Re: 13 oak ave / 4 torrington Peaks Island landscaping

Anne & John Belden
 4 Torrington /
 13 OAK AVENUE
 PEAK'S ISLAND
 4-10-2019

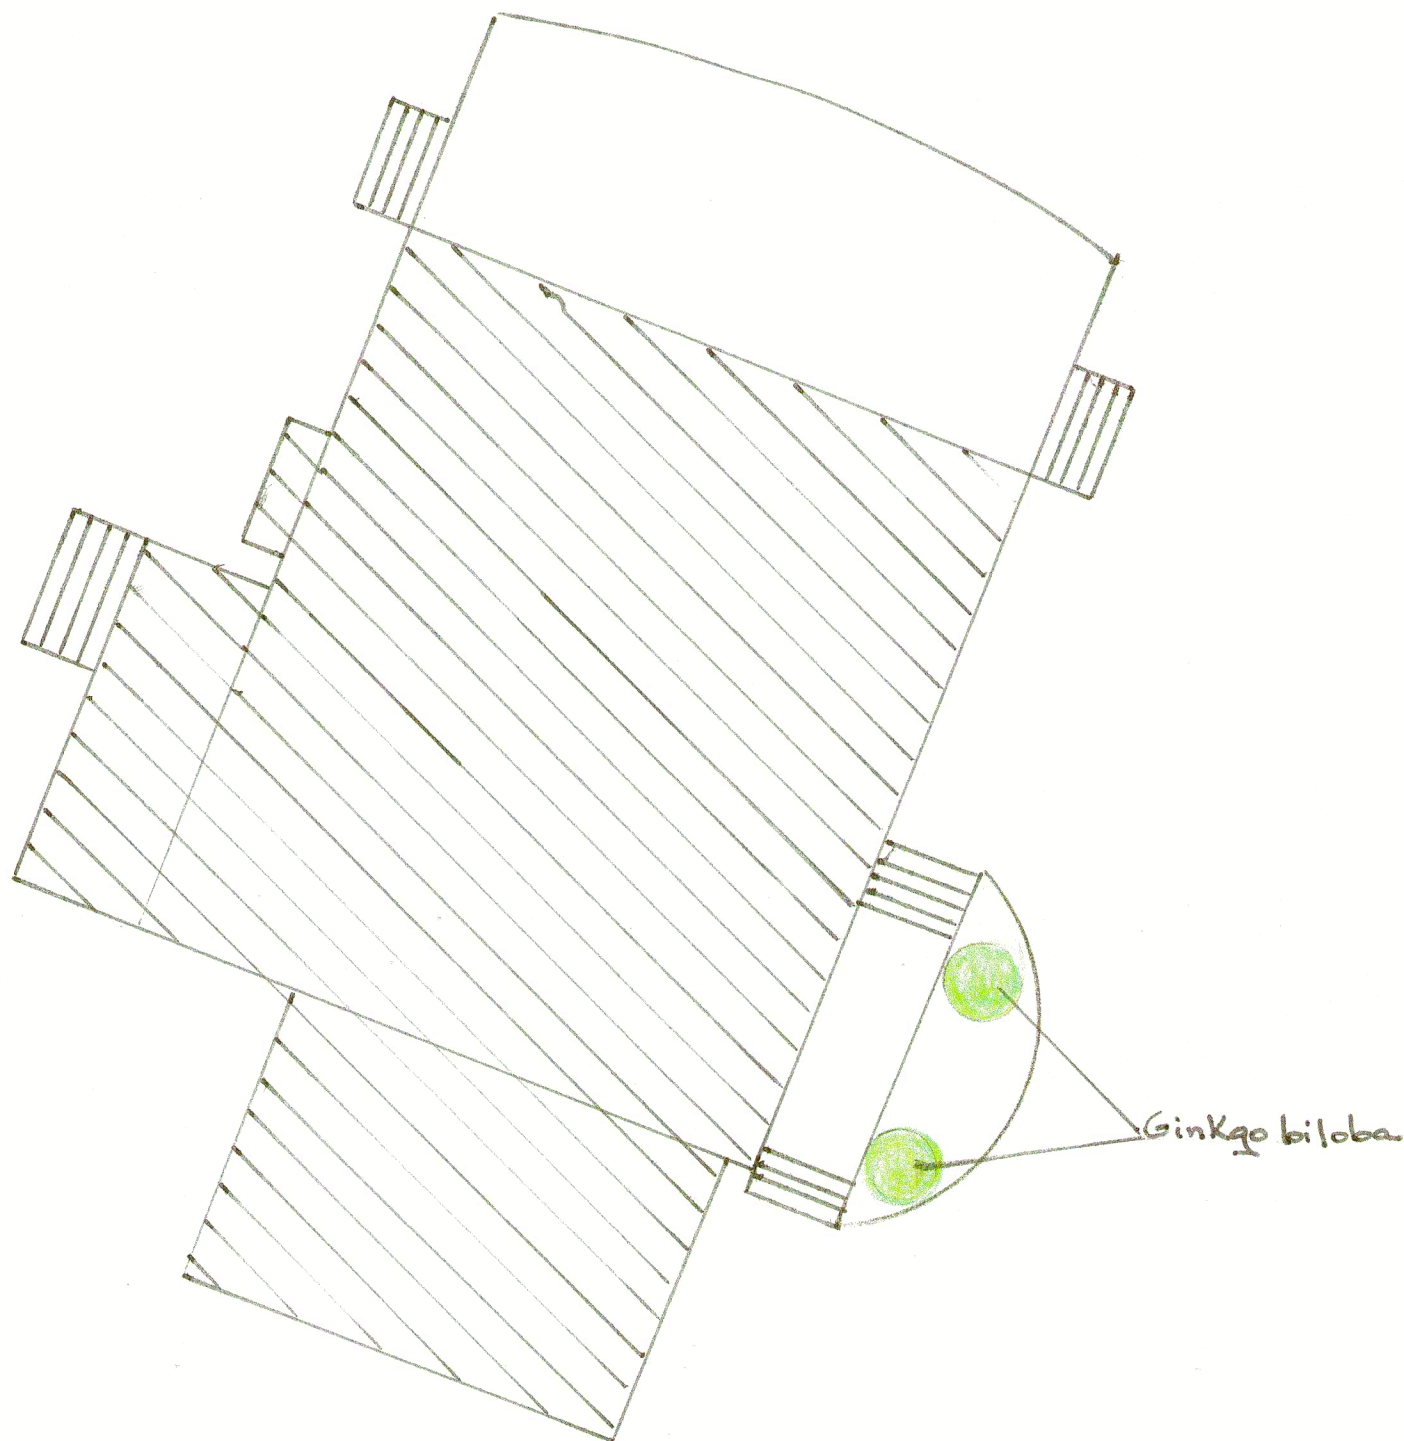
Thank you for dropping off the plan last week. I took a look at it today and had a couple of questions.

I am attaching a photo sketch - does this correctly depict the broad outlines of the area that will be impacted and the area that will not be cut? I realize this may not be a perfect representation, but I just want to make sure I'm grasping the general concept.

Also, could Donhovan or one of your other consultants confirm that the plants to be removed are all non-natives? The removal of the lilacs, wild roses, norway maples, honeysuckles, and bittersweet are acceptable. I just would like a firm confirmation that the areas marked "weeds" and "brush" definitely do not contain any native trees, saplings, shrubs, or ground covers. If any native plants are found during the clearing process, they must not be cut.

It appears that except for the lilacs and wild rose on the side of the house, all of the proposed clearing will be more than 75 feet from the highest annual tide.

The area you outlined is correct, except for the 2 lilacs on the side of the "driveway" area, which I believe I had noted on the overlay plan are to be pulled out and replanted with grasses.

I am approving the proposed clearing and planting plans with the following conditions:

- 1) It is the responsibility of the landowner and contractor to remain in compliance with the shoreland zoning regulations, Division 26 of the Chapter 14 Land Use Ordinance. Please reach out if any questions arise during the project.

- 2) The landowner and contractor will be responsible for ensuring that no native plant species are removed, unless found to be dead or dying.
- 3) The landowner shall be responsible for monitoring the plantings for a minimum of five years. If any of the plantings die during that time frame, they must be replaced in-kind.

- 4) The landowner and/or contractor shall photo document the clearing and replacement process, in case any questions arise about the scope of clearing. Photos of the completed project should be emailed to me.

- 5) A digital scan of the plans are required. I will leave the paper plans at the front desk with your name so you can pick them up. If you can take them to a copy center that has large-format scanning capability, and email me PDF's of the scans, I would appreciate it.
